PLAN-020028

17/10/2017

Proposal: Demolition & erection of 1 No. dwelling with integral garage.
Site: 72 Ancton Way, Elmer, Middleton on Sea, PO22 6JP.
M/94/17/PL

Proposed Site Plan

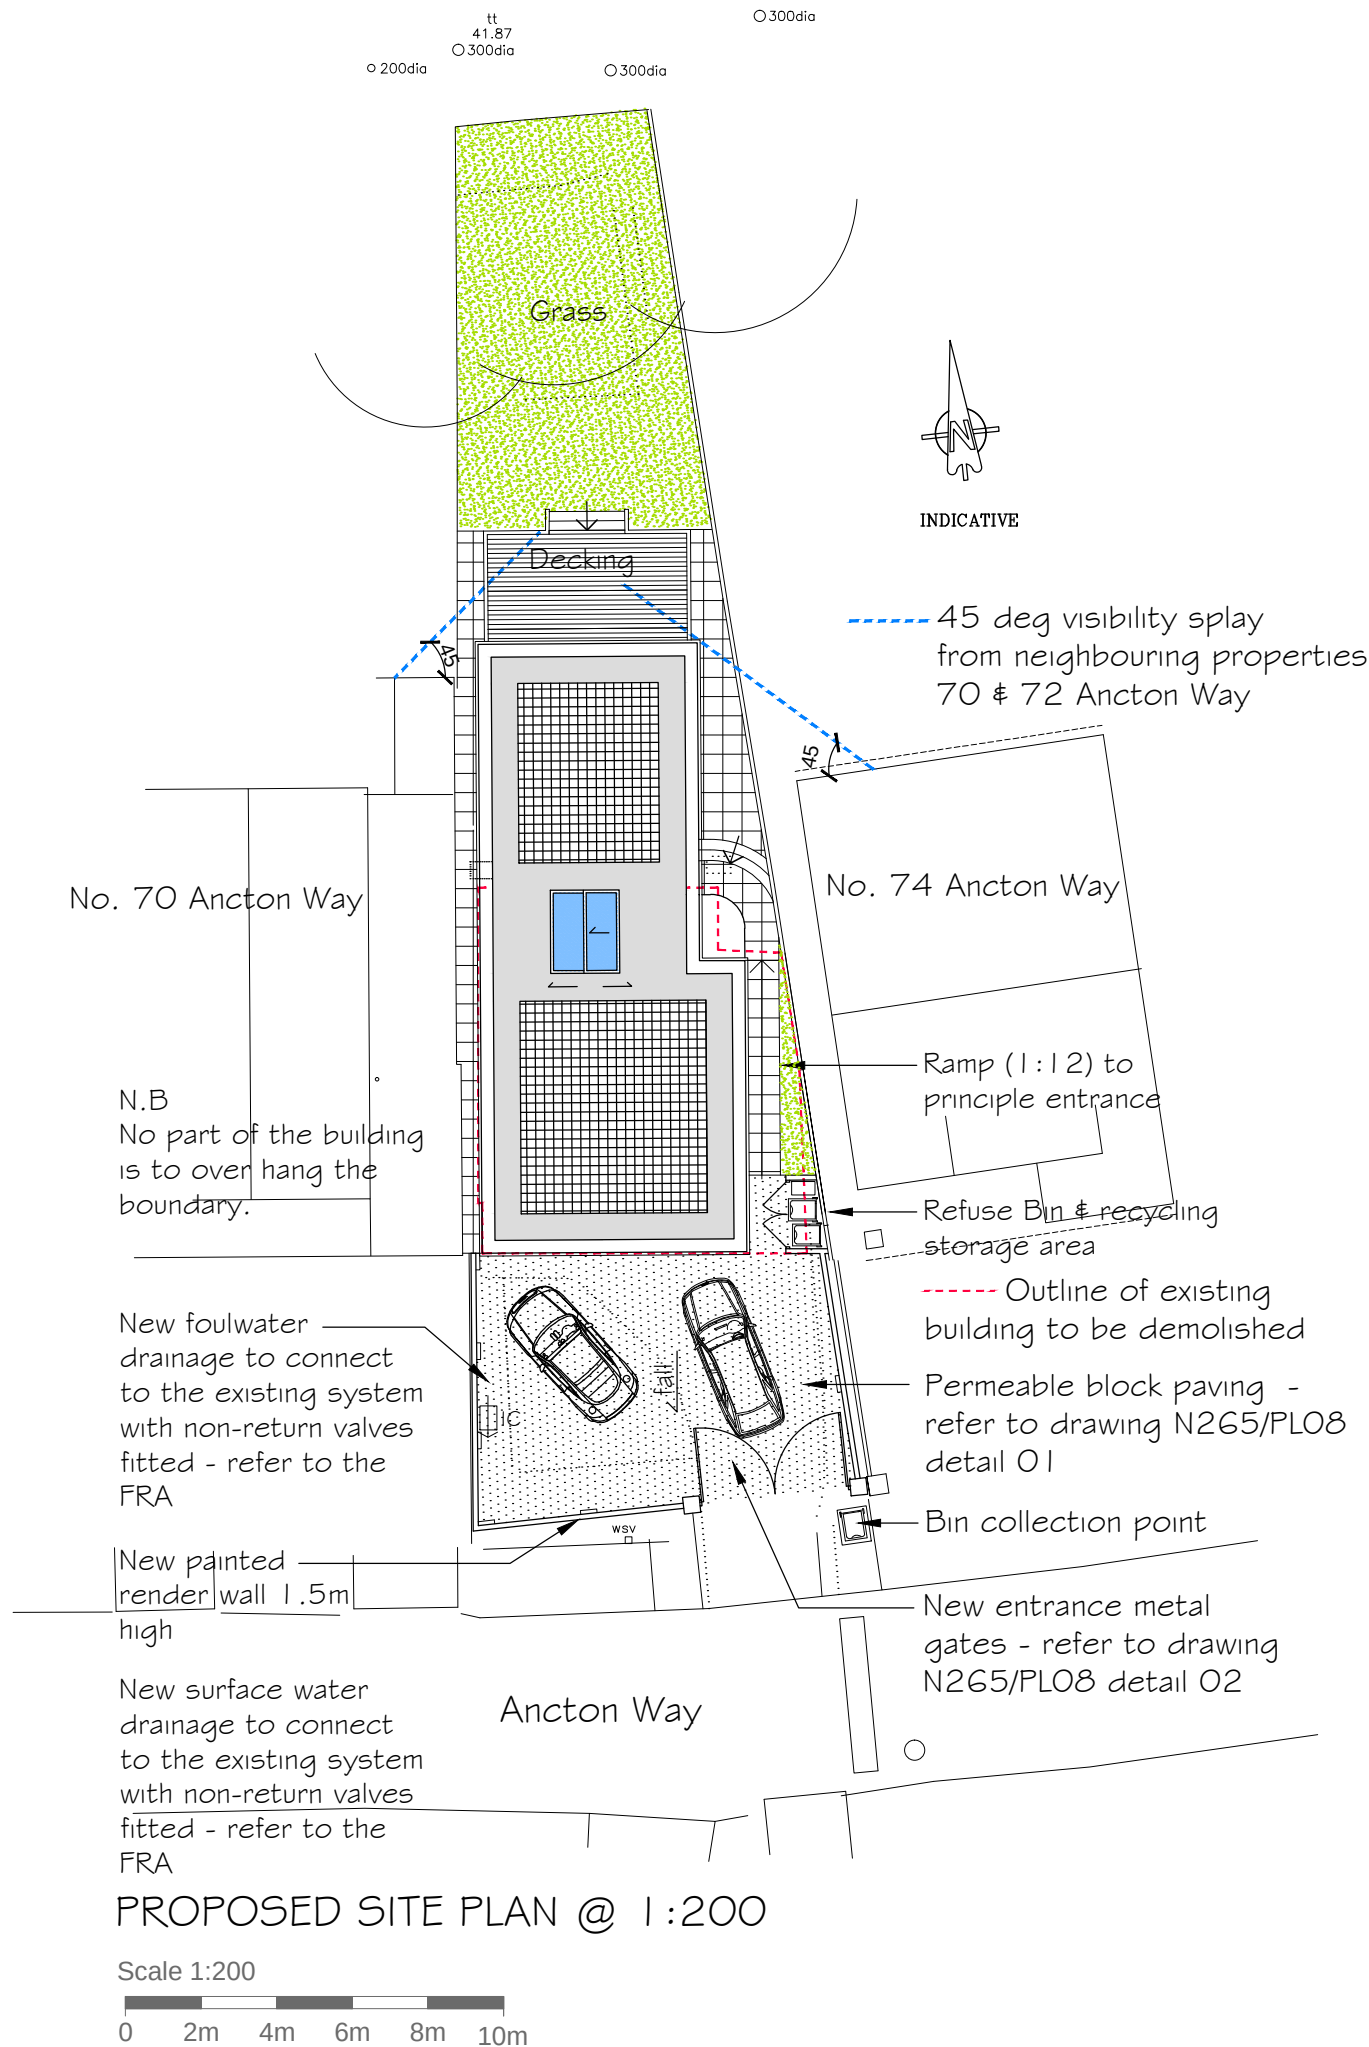
The submitted plans shows that there is a sewer crossing the site that might be public which not showing in our records. It might be possible to divert the public sewer, so long as this would result in no unacceptable loss of hydraulic capacity, and the work was carried out at the developer's expense to the satisfaction of Southern Water under the relevant statutory provisions.

1. The sewer requires a clearance of 3 metres either side of the sewer to protect it from construction works and allow for future access for maintenance.
2. No development or new tree planting should be located within 3 metres either side of the centreline of the public sewer
3. No new soakaways should be located within 5m of a public sewer.
4. All other existing infrastructure should be protected during the course of construction works.

Alternatively, the applicant may wish to amend the site layout, or combine a diversion with amendment of the site layout. If the applicant would prefer to advance these options, items (1) – (4) above also apply.

Our initial investigations indicate that there are no dedicated public surface water sewers in the area to serve this development. Alternative means of draining surface water from this development are required. This should not involve disposal to a public foul sewer.

The application details for this development indicate that the proposed means of surface water drainage for the site is via a watercourse. The Council's technical staff and the relevant authority for land drainage consent should comment on the adequacy of the proposals to discharge surface water to the local watercourse.

In order to protect drainage apparatus, Southern Water requests that if consent is granted, a condition is attached to the planning permission. For example "The developer must advise the local authority (in consultation with Southern Water) of the measures which will be undertaken to divert the public sewers, prior to the commencement of the development."
